Request for Clarification of Information

Address: 142 Douglass Street

Permit #: 2017-00352

Date: 4/18/2017

Mud Room
 CROSS SECTION
 SCALE 1/4" = 1'-0"

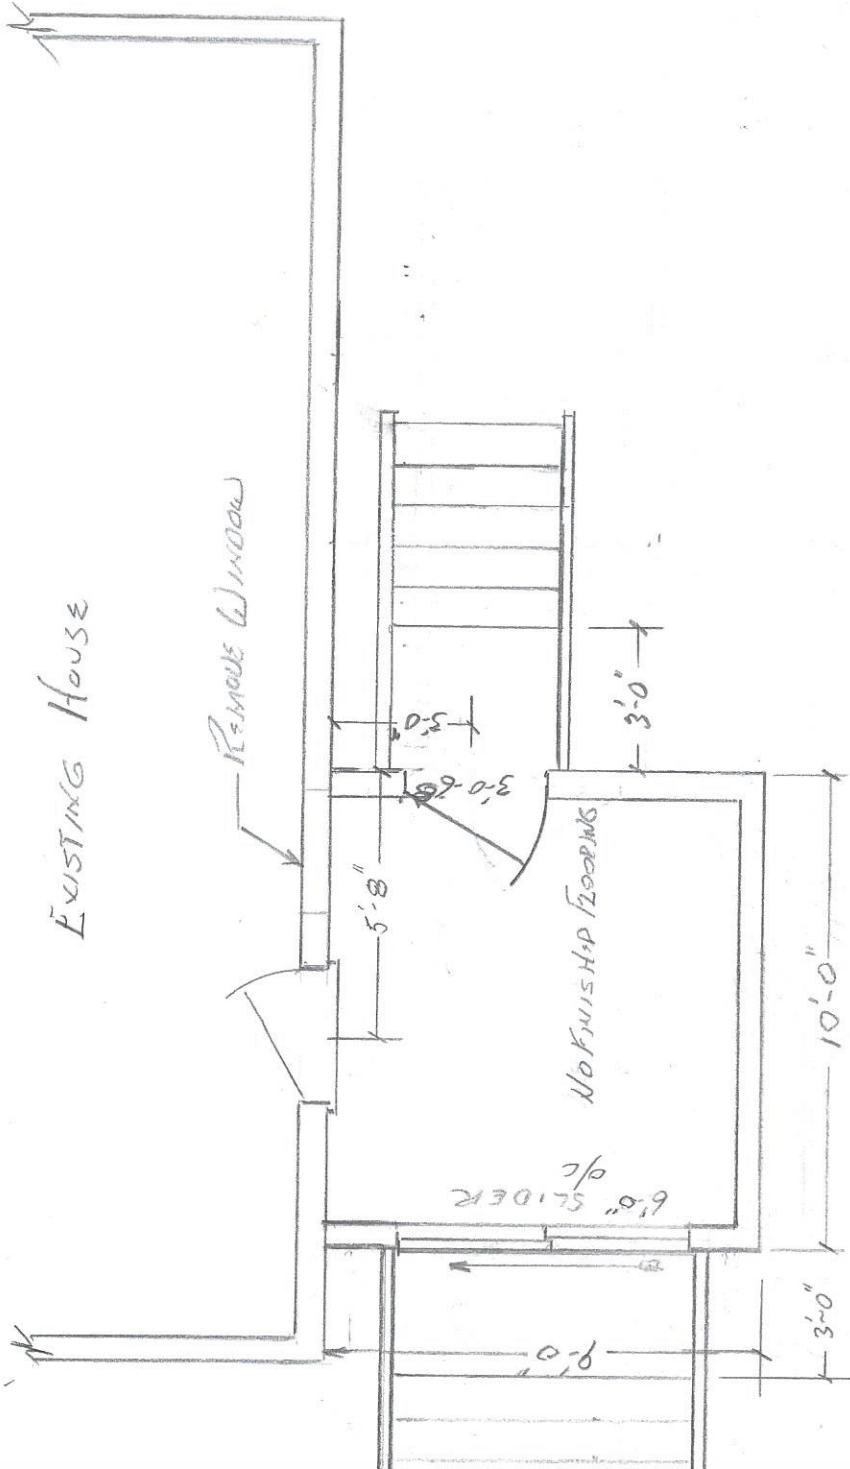
1. Please make sure that all copies/scans are fully readable ✓
- ✓ 2. Submit a plan / section showing the framing and the connection details of the mudroom *Cross Section*
- ✓ 3. Specify the ties and ceiling / roof framing
4. Will the ceiling be closed or open framing? *Yes, ceiling will be closed or open Framing with Sheetrock*
5. Specify the sheathing to be used on the floor, walls and roof *7/16" ZIPboard wall sheathing & 5/8" roof ZIPboard sheathing*
- ✓ 6. Show the porch framing and connections to the mudroom
7. Will the mudroom be insulated space? *Yes, R-21 in walls & 12" Fiberglass in ceiling & Fiberglass 9 1/4" in Floor*
- ✓ 8. Specify the mechanical fasteners and connection.
